Application No: Y/1/26/HH
Site Address: 34 Downview Close Yapton BN18 0LD
Description of works: First floor extension.

Thank you for your internet representation made on 16th February 2026 which has been recorded as an objection with the comments as follows:

WEST ELEVATION SCALE 1:100

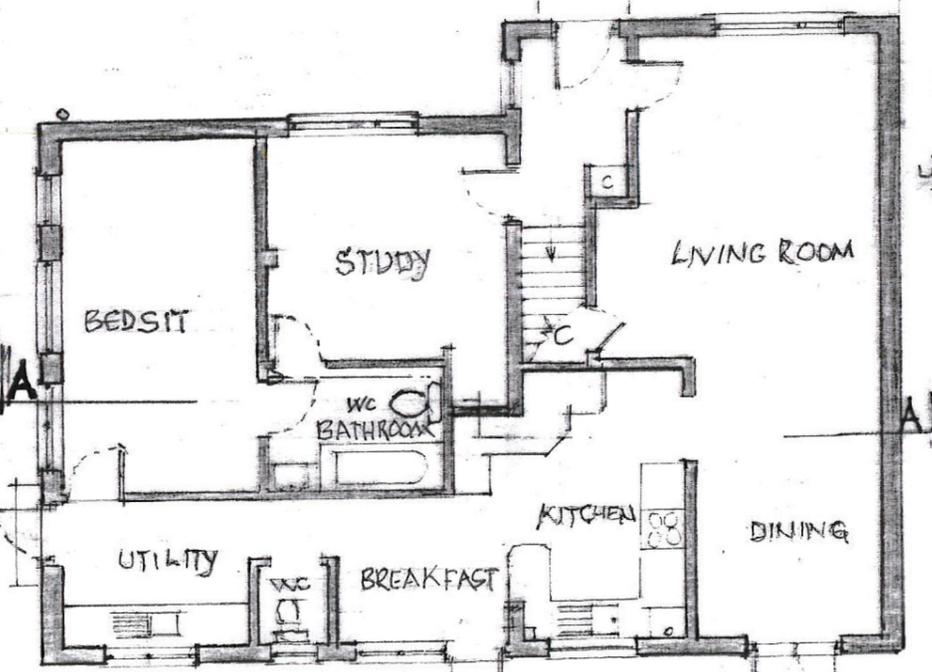
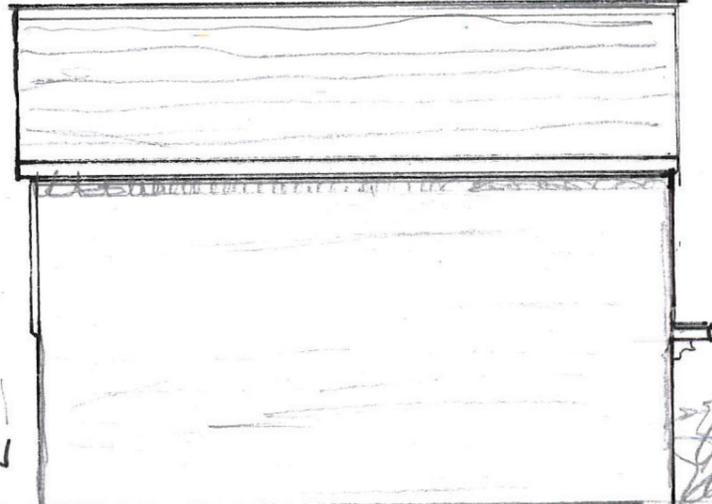
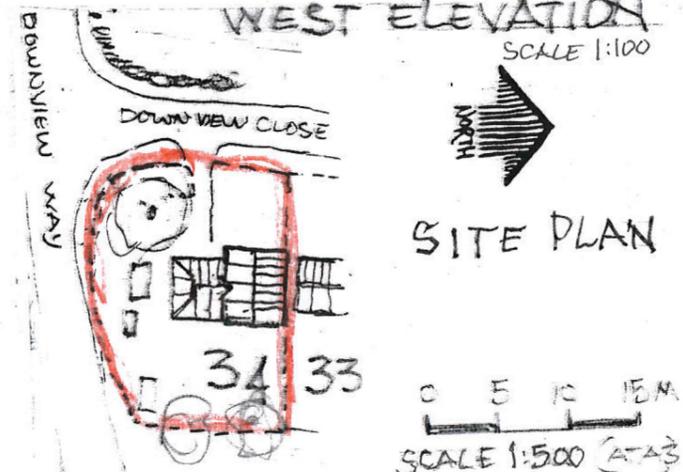
Yapton Parish Council objects on the basis of inappropriate massing and size for the plot as a prominent corner plot.

The proposed extension doubles the size of the dwelling where it is a first floor addition on an existing ground floor extension, making the house significantly larger in mass and appearance to the general streetscape within Downview Close/Way. A smaller extension would be deemed acceptable but not at the current massing.

The western elevation is overbearing in roofing materials and elevational treatment. It is very visible in streetscape terms and will negatively impact the the visual amenity of Downview Close and Downview Way.
